From: Bloomer, David <David.Bloomer@lancashire.gov.uk>
Sent: 25 June 2018 11:55
To: Rebecca Bowers
Cc: LHS Customer Service; planning
Subject: app3/2018/0531 Clitheroe Health Centre Railway View Road

Dave Bloomer
Development Control
Lancashire County Council

Rev	Date	Drawn By	Comments
Client			
NHS Property Services Ltd			
Project			
Clietheroe Health Centre - Bin Store			
Drawing			
Proposed Plan and Elevations			
Drawing Number		Drawing Type	
0384.P.02		Planning	
Drawn By		Scale @ A3	Date
R.G.		AS Shown	Apr 2018

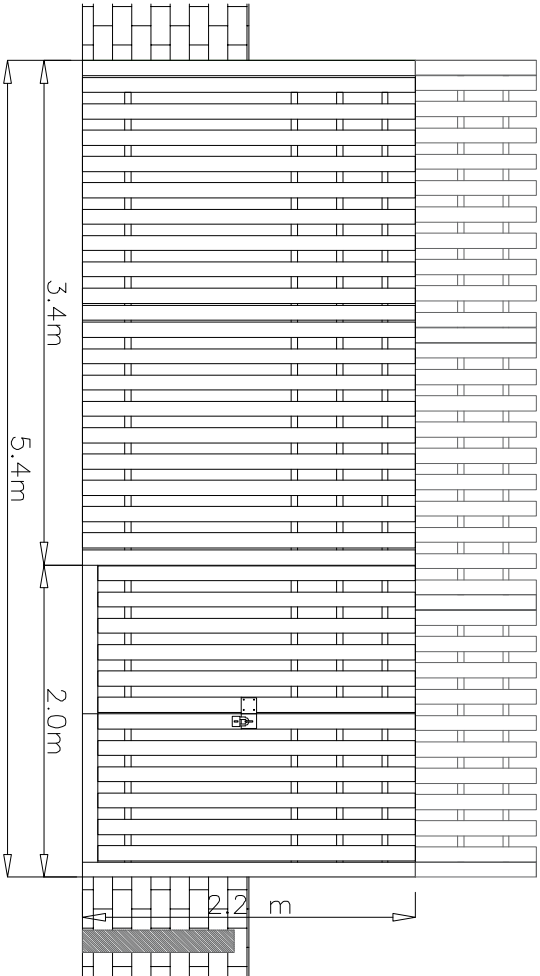
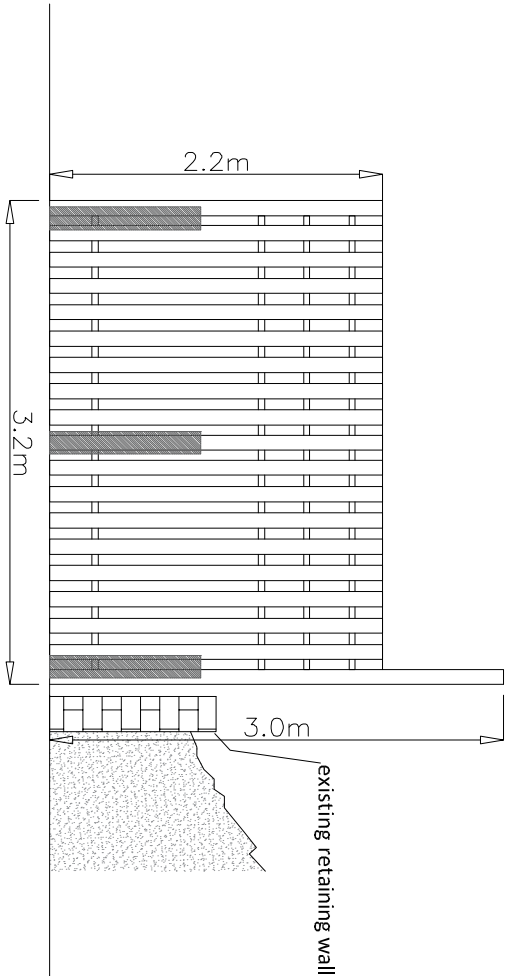
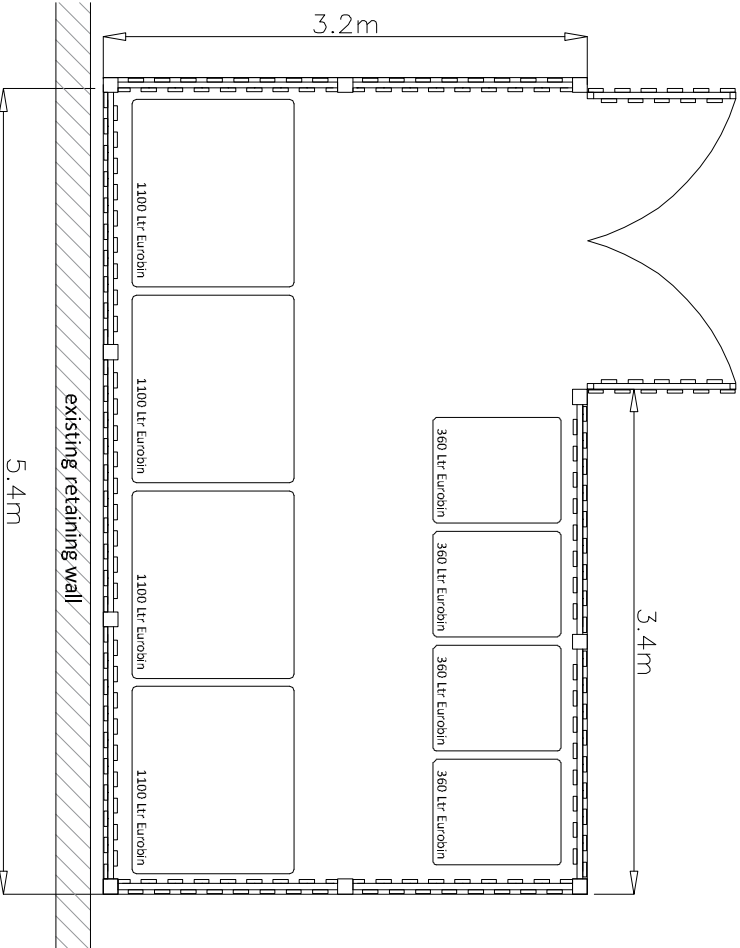
The proposal raises no highway concerns and I would therefore raise no objection to the proposal however care should be exercised when erecting / positioning the external light top ensure that it dazzle / distract users of the adjacent highway.
